**Planning Department
Transportation Development Services**

Re: Wendy's, 3601 4th St. NW
Traffic Circulation Layout
Architect's Stamp dated 07-14-14 (G14-D031)

Re: Wendy's, 3601 4th St NW
Traffic Circulation Layout
Architect's Stamp dated 6-26-14 (G14-D031)

REMODEL AND TCL SITE PLAN

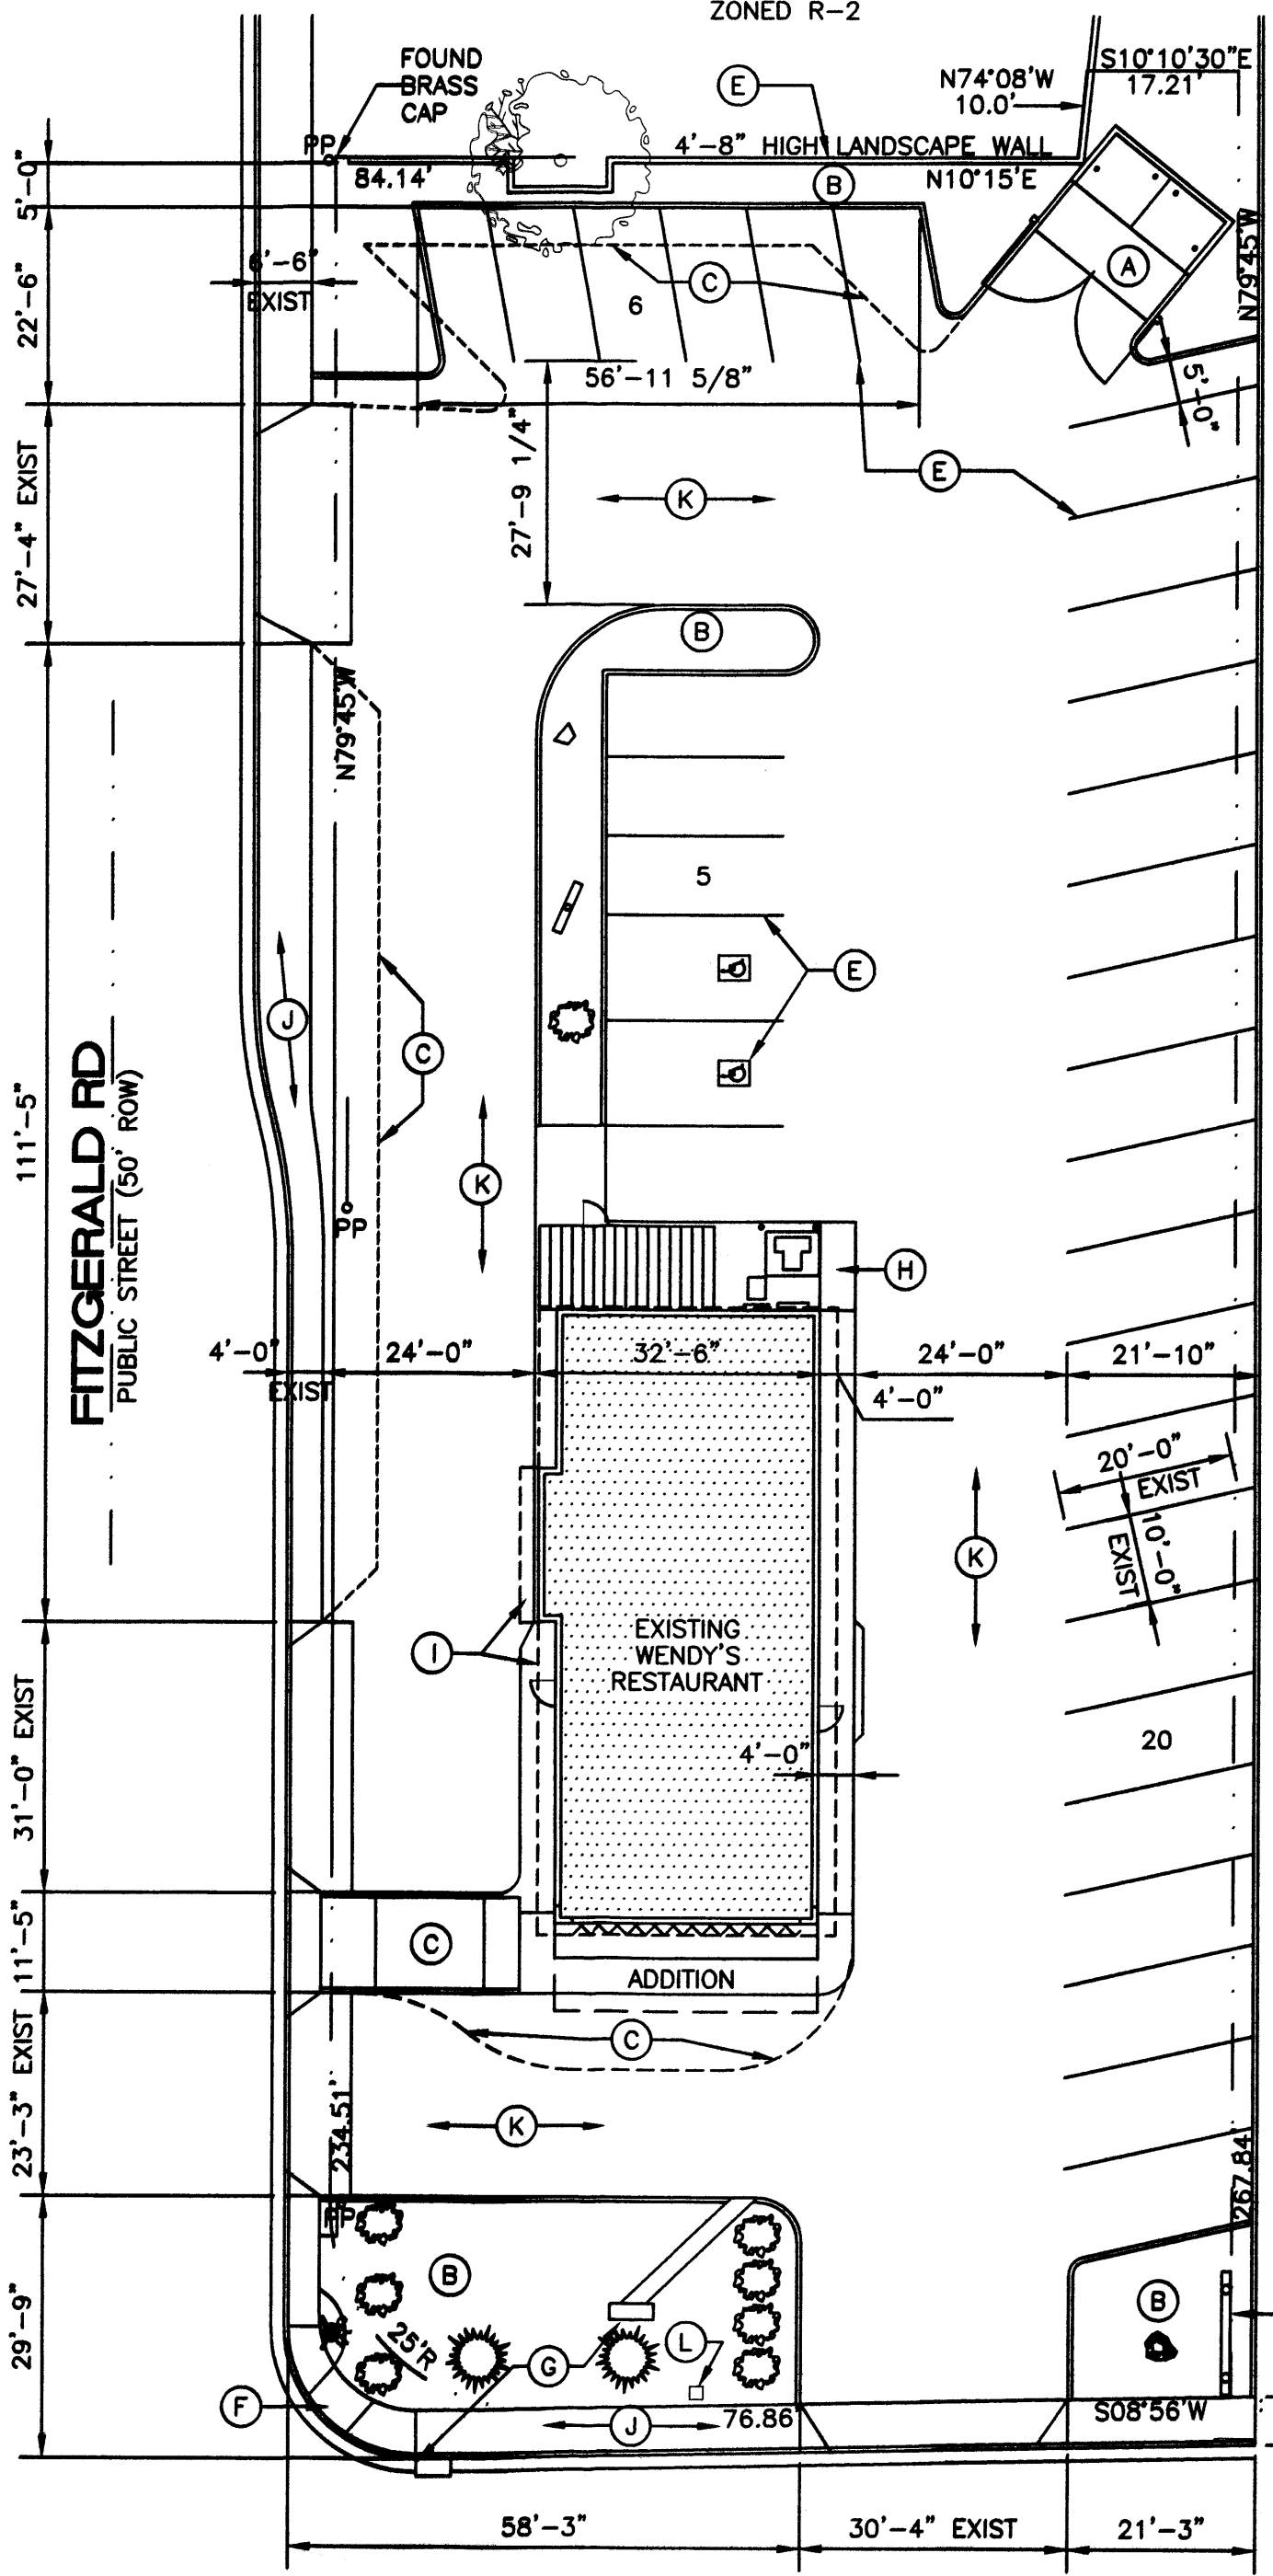
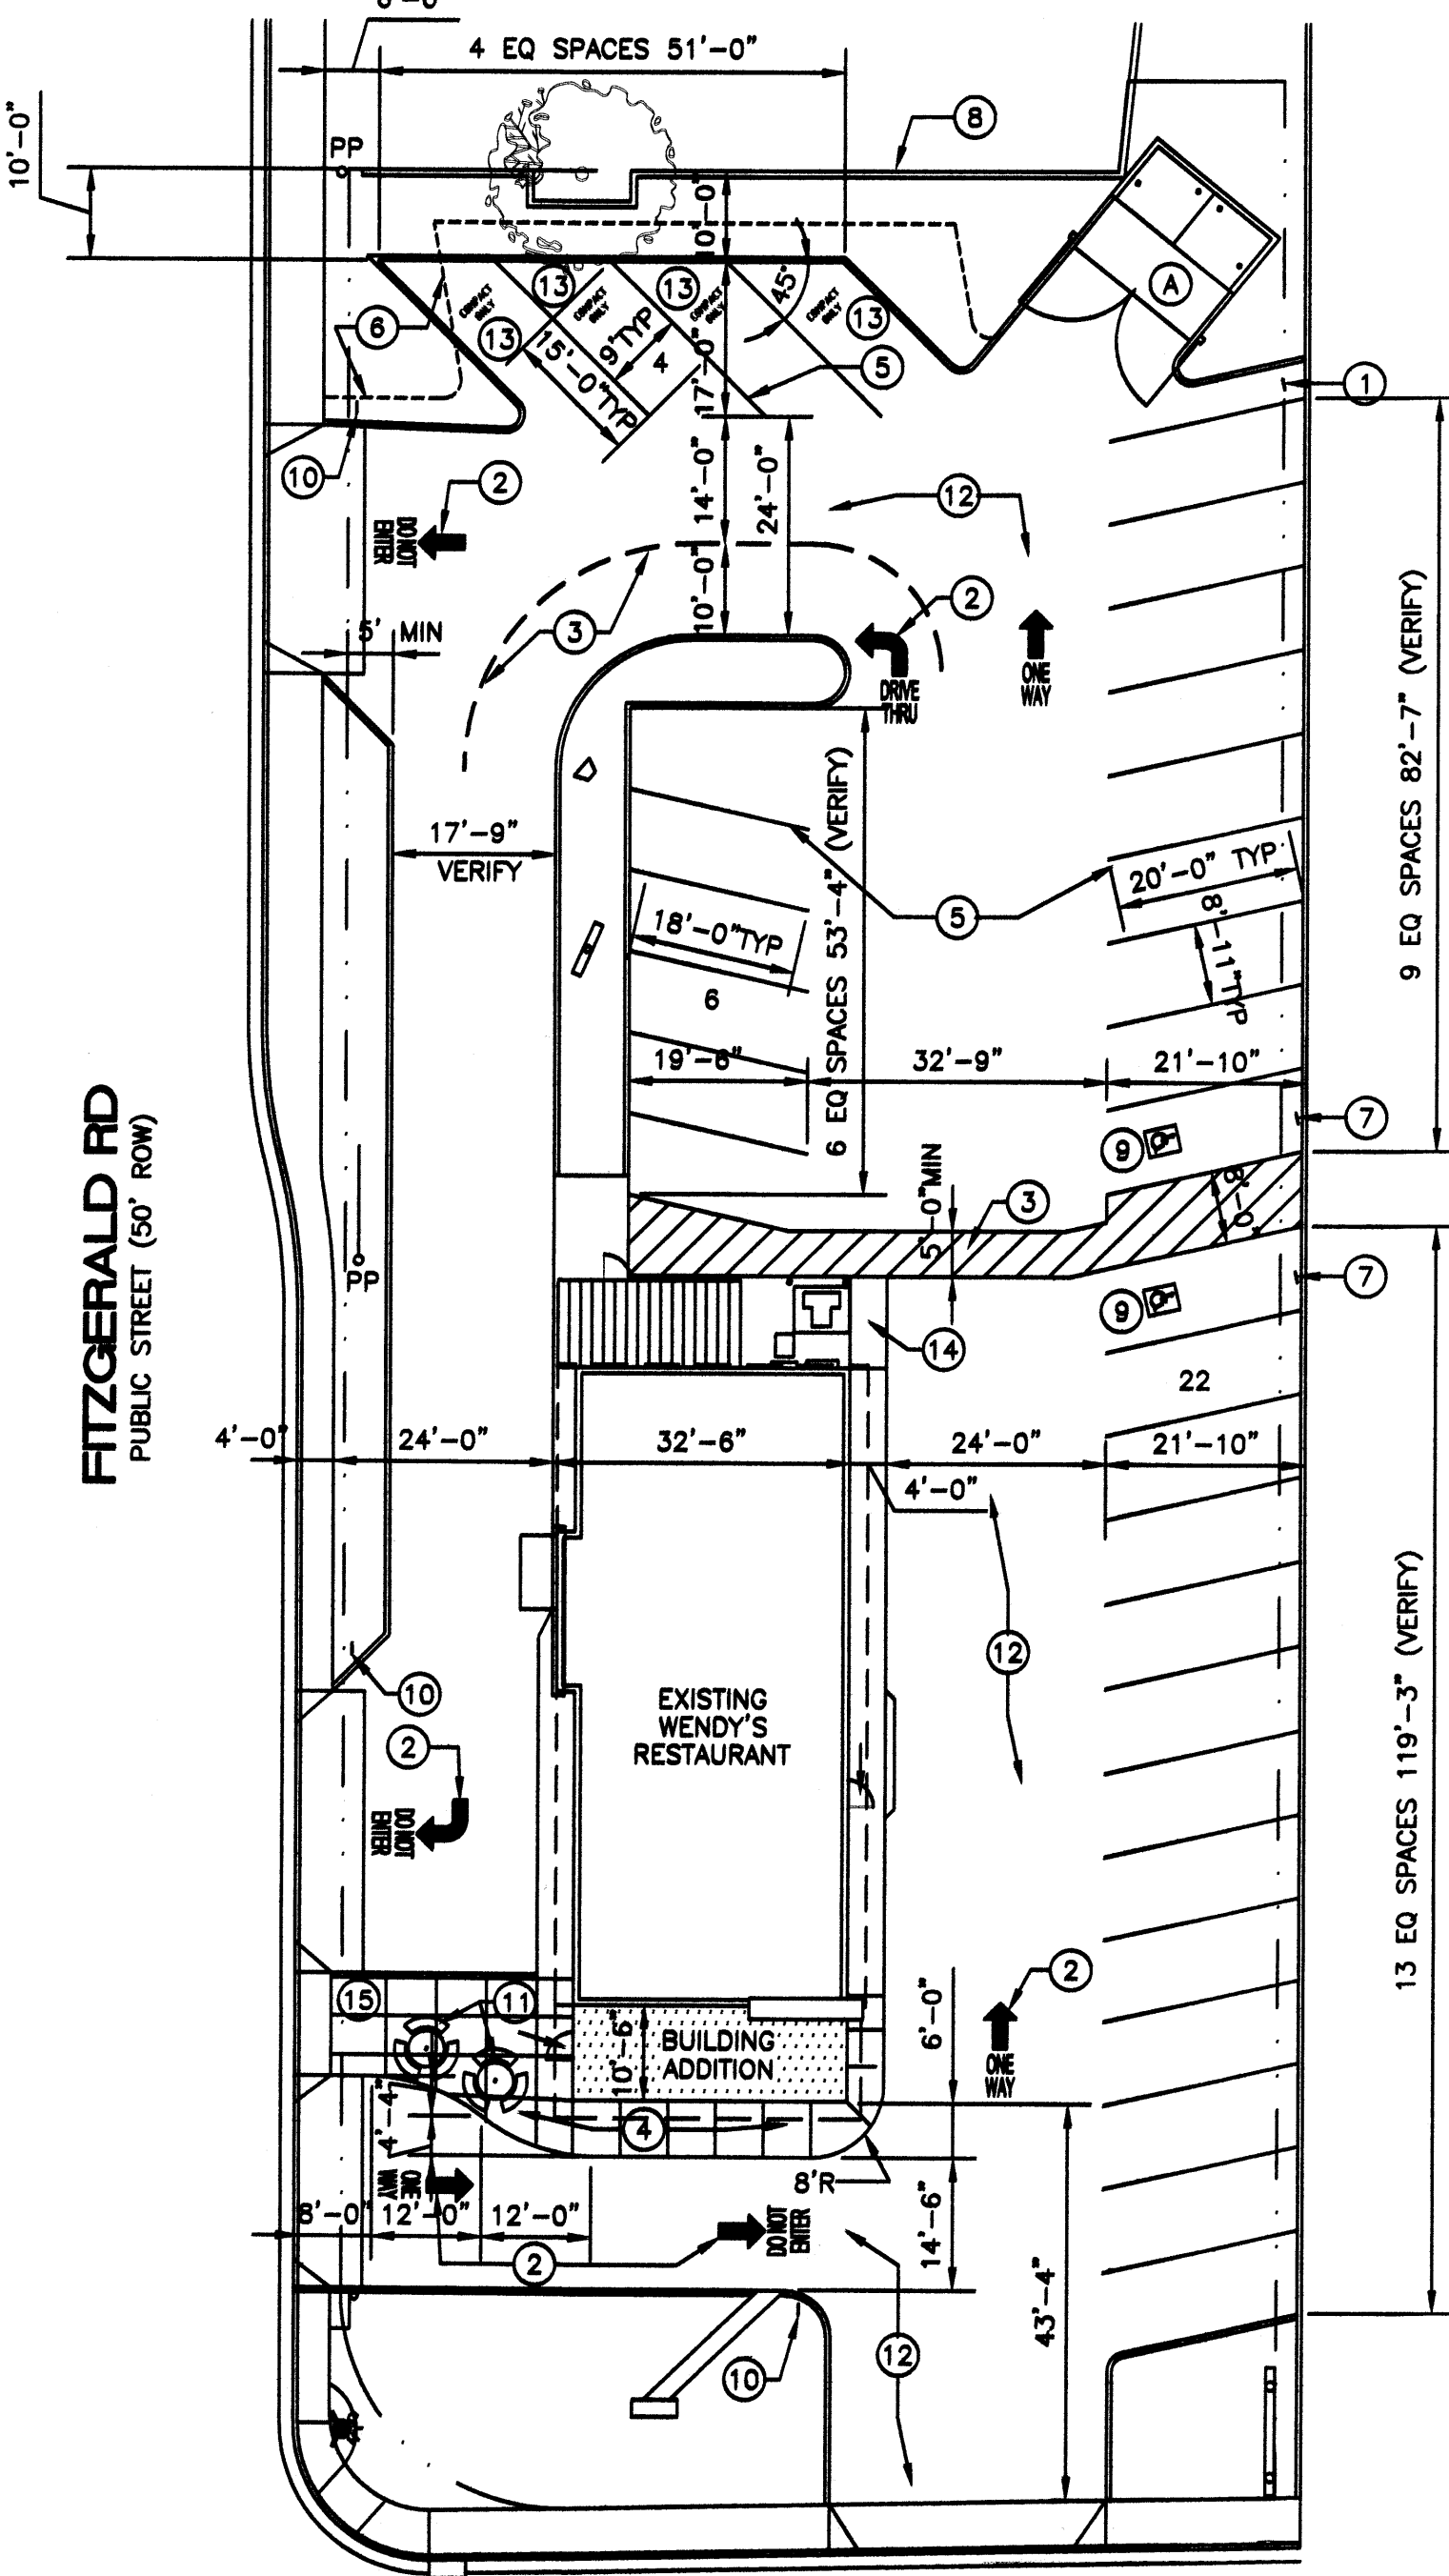
- ①. Please list the width and length for all parking spaces.
2. ✓ Please show a vicinity map.
- ③. The handicap accessible spaces must be a minimum of 8.5 feet in width.

4. ✓ The handicap accessible spaces must include an 8-foot wide van access aisle; all other aisles should be 5 feet in width.
5. ✓ Please provide a detail of the handicap accessible parking signage

- ⑥. Provide a heavy vehicle pathway on the plan.
7. ✓ Please include two copies of the traffic circulation layout at the next submittal.
8. ✓ Show the pedestrian pathway and ADA access to the building including all ramps.

9. ✓ How will ADA access be taken to the entrance of the building? The door appears to swing in the path way.
10. Please provide an easement for any sidewalk within the right-of-way.

11. ✓ Please provide approvable signage and striping i.e. one-way and do not enter.
12. ✓ Please remove non applicable note "7" from the TCL plan.
13. ✓ We suggest that the parking on the west end of the property be changed to compact parking to widen the drive aisle.
